From: Hornby, Mark [Mark.Hornby@lancashire.gov.uk]
Sent: 09 November 2012 11:54
To: Graeme Thorpe
Cc: ENV EPP Customer Service Area East
Subject: FW: Consultation on planning application 3/2012/0874 land adj St Leonards Vicarage, 11 Whalley New Road, Billington

Provided that the access improvements detailed on submitted Plan No. V.200-361.A/02 Revision A are implemented I have no objection to the proposed development.

PAPER SIZE: A1	DRAWING NUMBER: V.200-361.A/02	REV B
SCALE: 1/200	DATE: February 2012	DRAWN BY GM

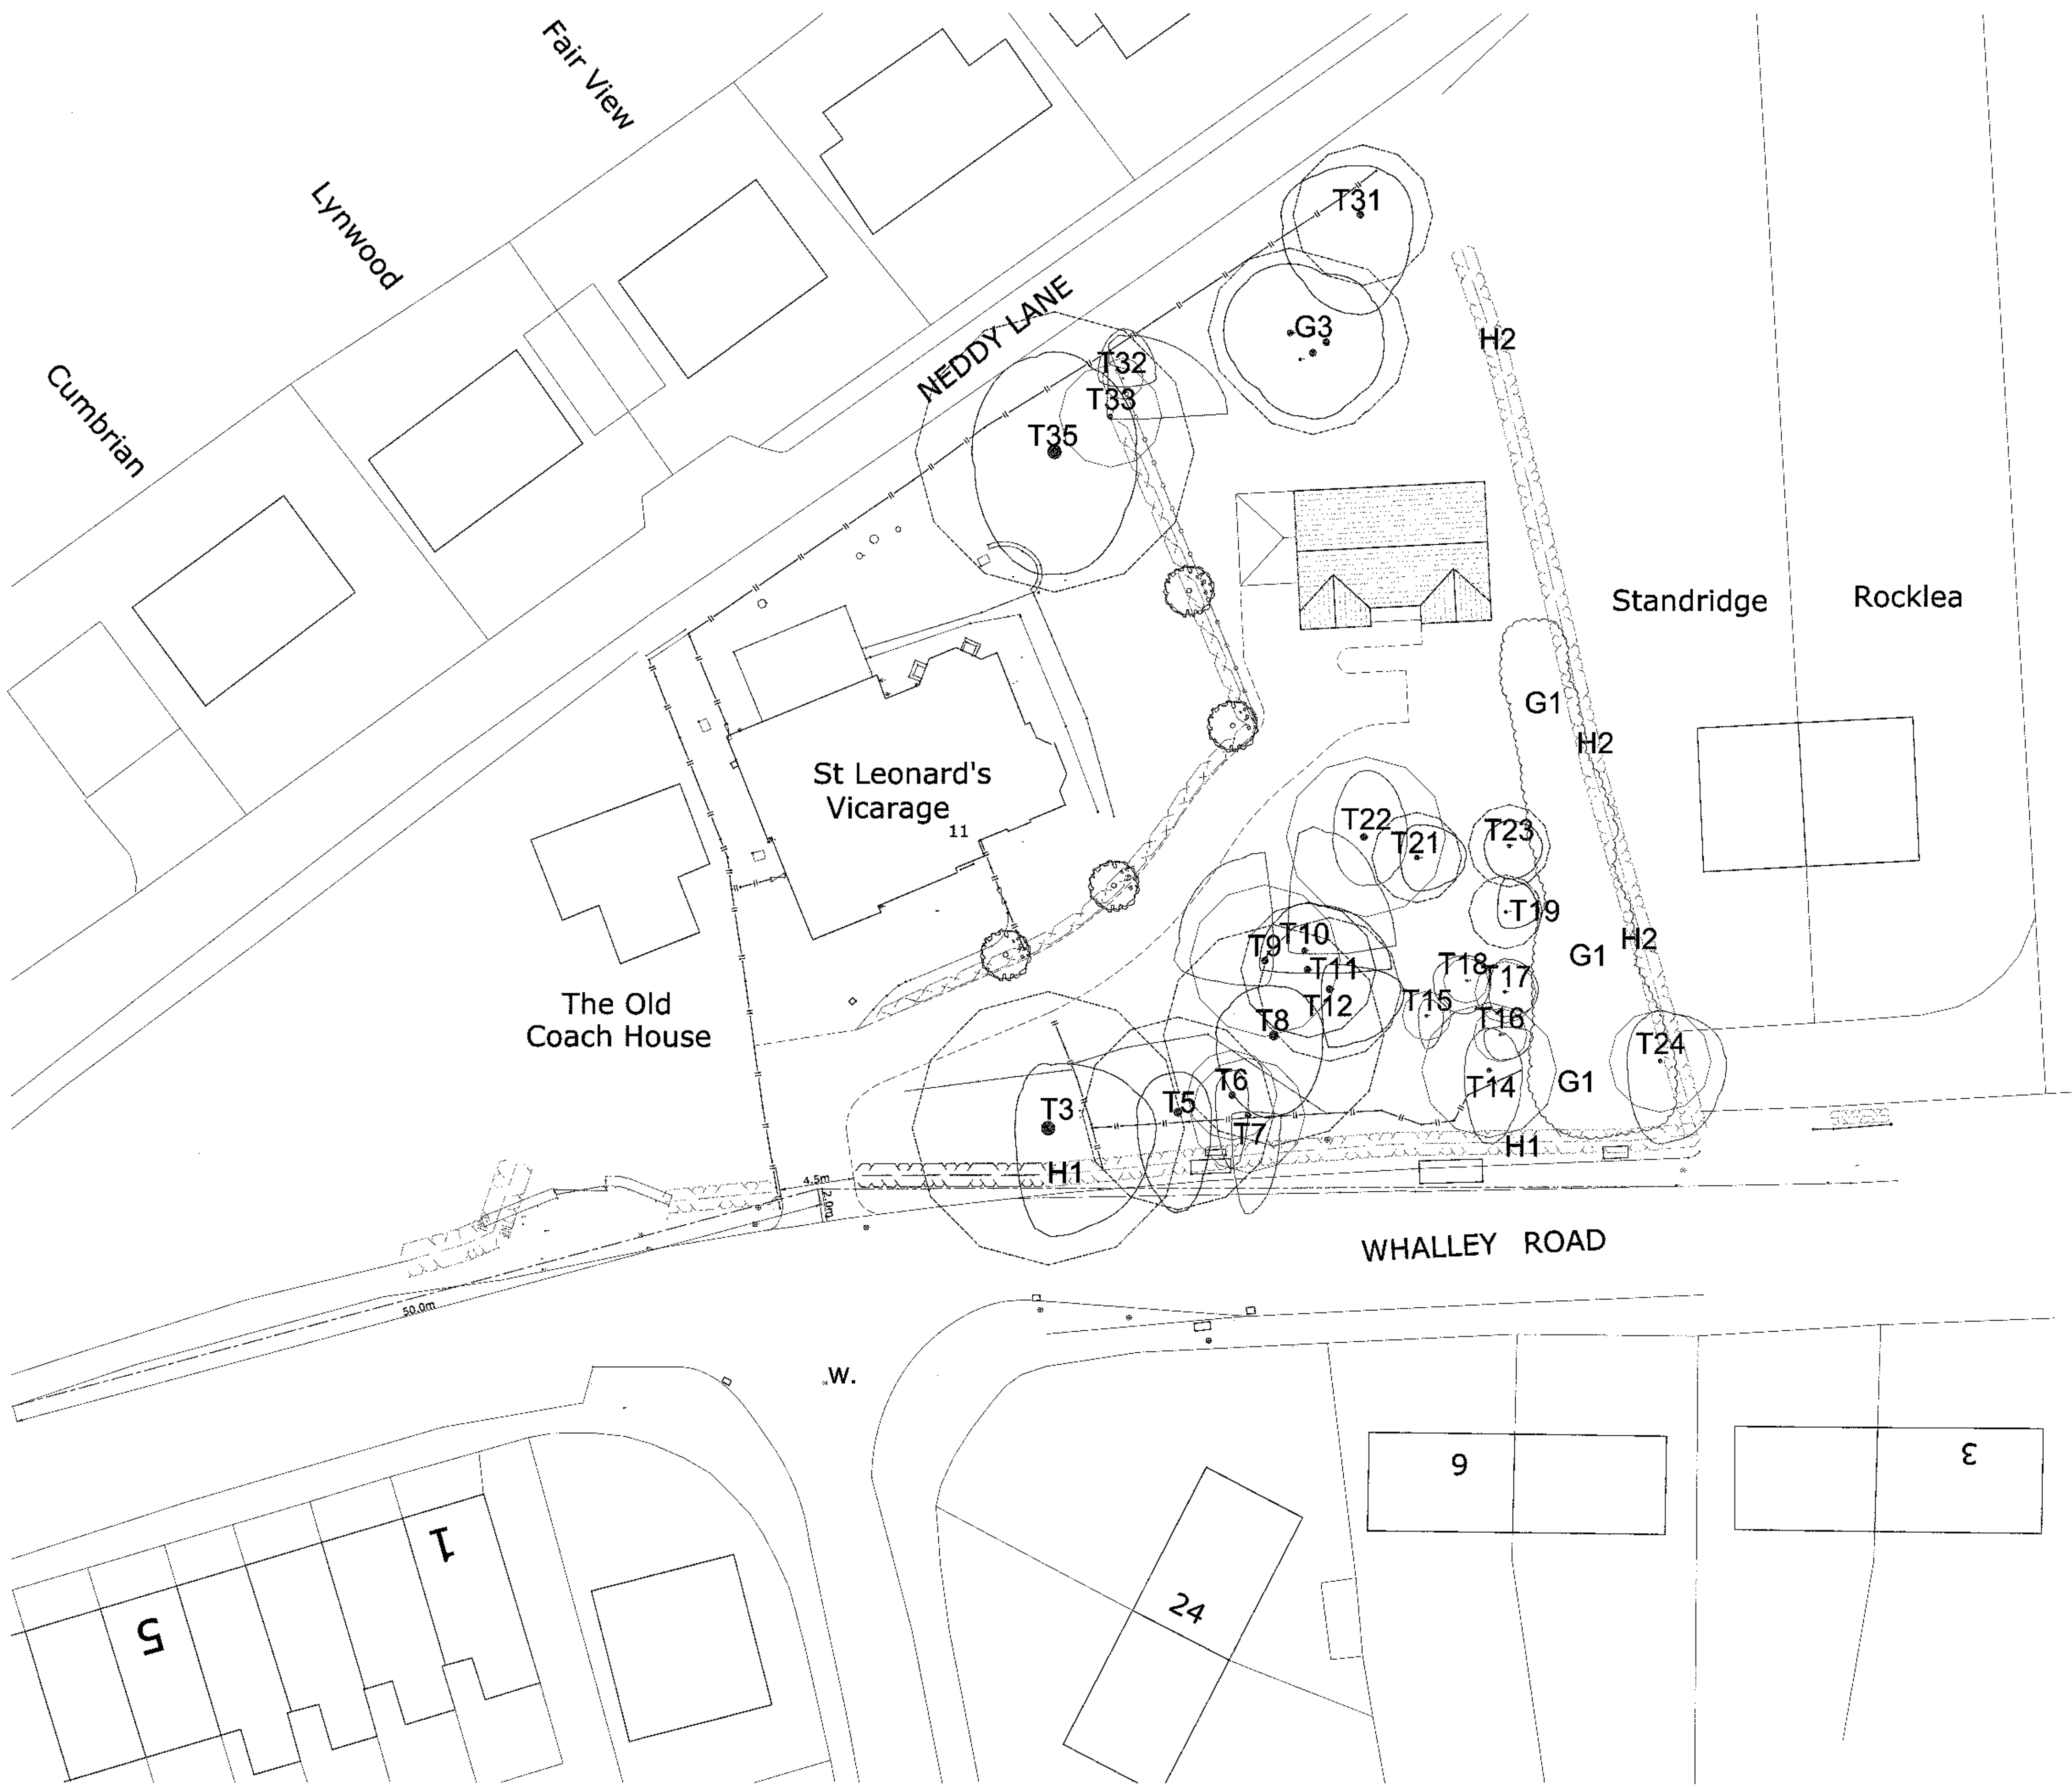
1. The existing access driveway shall be widened to a 4.5m width as shown on Plan No. V.200-361.A/02 Revision A. Reason: To enable vehicles to pass each other when entering and leaving the site simultaneously in the interests of highway safety.

4. The vehicular parking and turning space shall be laid out as shown on Plan No. V.200-361.A/02 Revision A and be available for use before the development is brought into use. Reason: Vehicles reversing to and from the highway are a hazard to other road users.
